Report of the Head of Planning, Transportation and Regeneration

Address 31 ST EDMUNDS AVENUE RUISLIP

Development: Demolition of existing garage and erection of outbuilding including a decking area to rear garden (Application for a Certificate of Lawful Development for an Existing Development)

LBH Ref Nos: 58245/APP/2021/4066

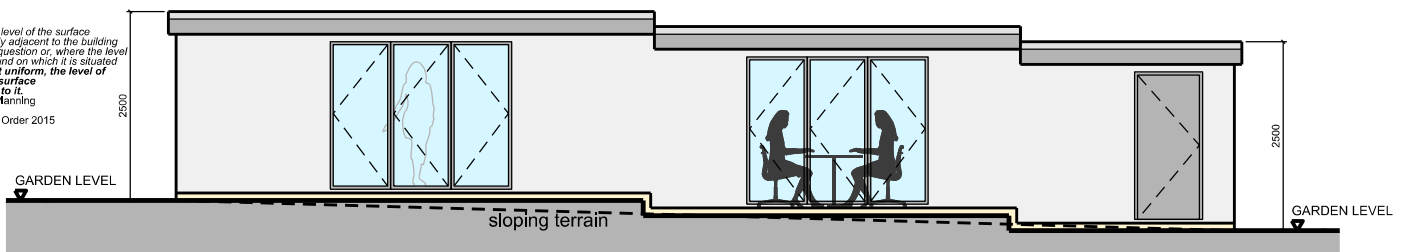
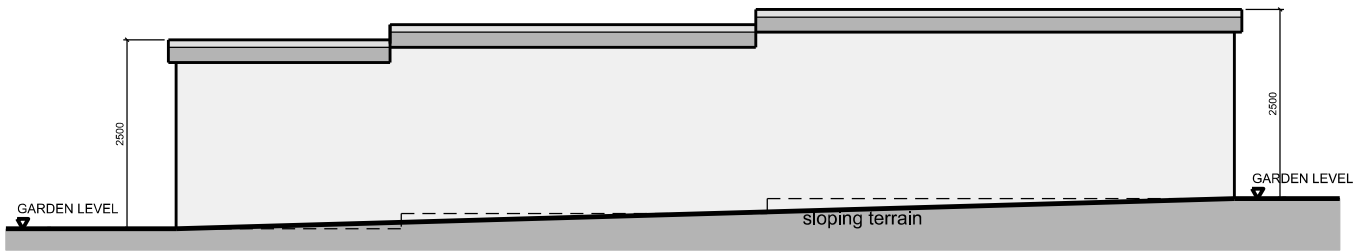
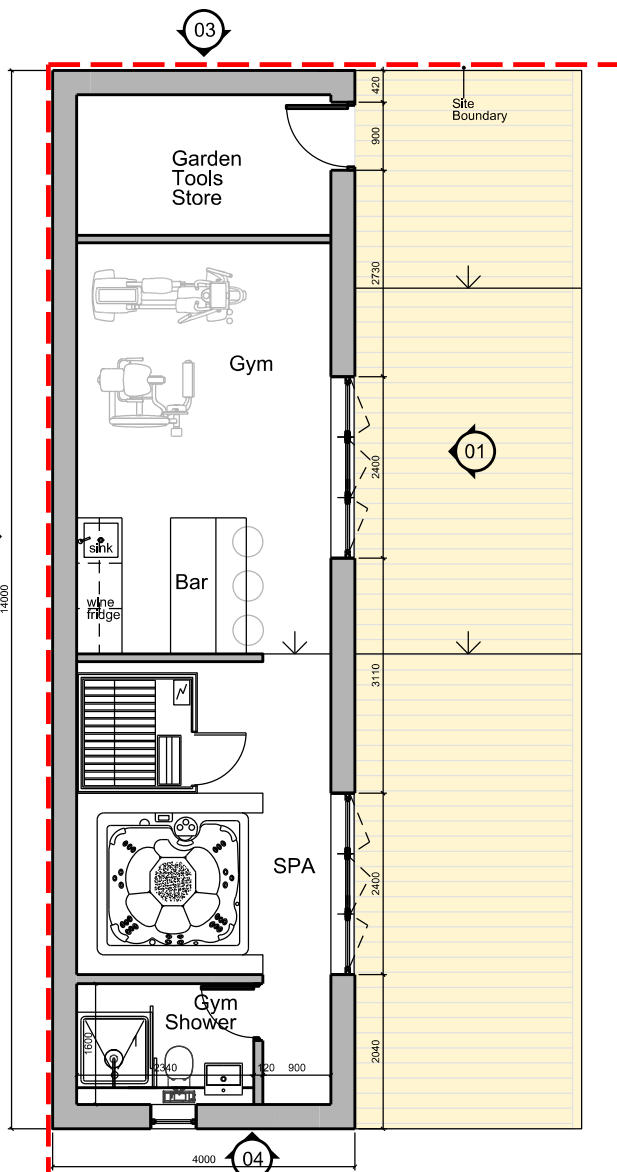
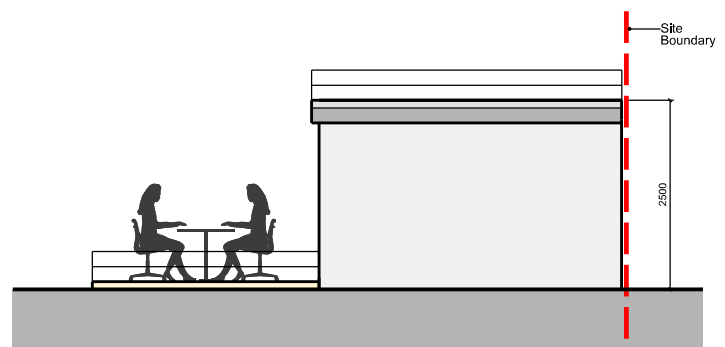
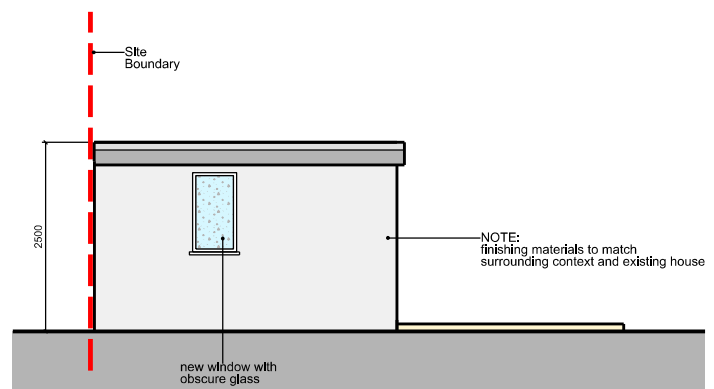
In this case, the constructed outbuilding measures approximately 14 metres in length and 4 metres in depth. It has a footprint of approximately 56 square metres, which equates to 65% of the original ground floor footprint of the host property. As such, it is considered that the size of the outbuilding is not commensurate to the size of the dwellinghouse. Notwithstanding this, it is noted that the size of an outbuilding is not, in itself, determinative of whether a development falls within the provision of Class E. It is also necessary to look at the function of the space within the outbuilding and determine whether the outbuilding is reasonably required for a purpose incidental to the enjoyment of the dwelling.

In this case, the submitted plans show that the outbuilding contains a spa, bar/gym (including a kitchenette) and a garden tools store. However, no details have been provided to explain why such facilities are required in connection with the host dwelling. The burden of proof rests with the applicant and the appropriate test of evidence is the balance of probabilities. In this particular case, apart from the labelling of the outbuilding for a variety of uses, no further information has been provided. Consequently, on the evidence available, it is considered, as a matter of fact and degree, that it has not been demonstrated that on the balance of probabilities the constructed outbuilding is reasonably required for purposes incidental to the enjoyment of the dwellinghouse.

In this case, the submitted drawings shows constructed outbuilding is positioned along mutual boundary shared with No. 33. The annotations on the drawings indicate that the outbuilding has a maximum height of 2.5 metres. However, it is not clear from the submitted drawings as to whether the existing ground level, is as a matter of fact and degree, the natural ground level of the site. From reviewing the notes and photographs submitted by the enforcement officer who conducted the original site visit, it is clear that the properties in this section of St. Edmunds Avenue have a natural decline from west to east. The officer site photographs (enforcement report) also shows that the ground levels at the site have been altered. There is therefore ambiguity in respect to the maximum height and eaves height of the constructed outbuilding in relation to the natural ground level of the site.

Having regard to the above, it is considered that the submitted information does not conclusively show that the outbuilding complies with provision E.1 (e)(ii) and (f), Class E, Part 2, Schedule 2 of the GPDO, in respect to its maximum height and eaves height.

The floor plan shows a decking area running across the full width of the constructed outbuilding. The submitted drawings indicate that this decking area has a height of 10 cm. However, as stated in the preceding paragraphs, it is unclear whether the ground level shown on the submitted drawings, is as a matter of fact and degree, the natural ground level of the site. It is therefore considered that insufficient evidence has been submitted to conclusively demonstrate that the decking area would not constitute as a raised platform.

As such, the decking area is not considered permitted by provision E.1 (h), Class E, Part 1, Schedule 2 of the GPDO and provision A.1 (k)(i), Class A, Part 1, Schedule 2 of the GPDO.
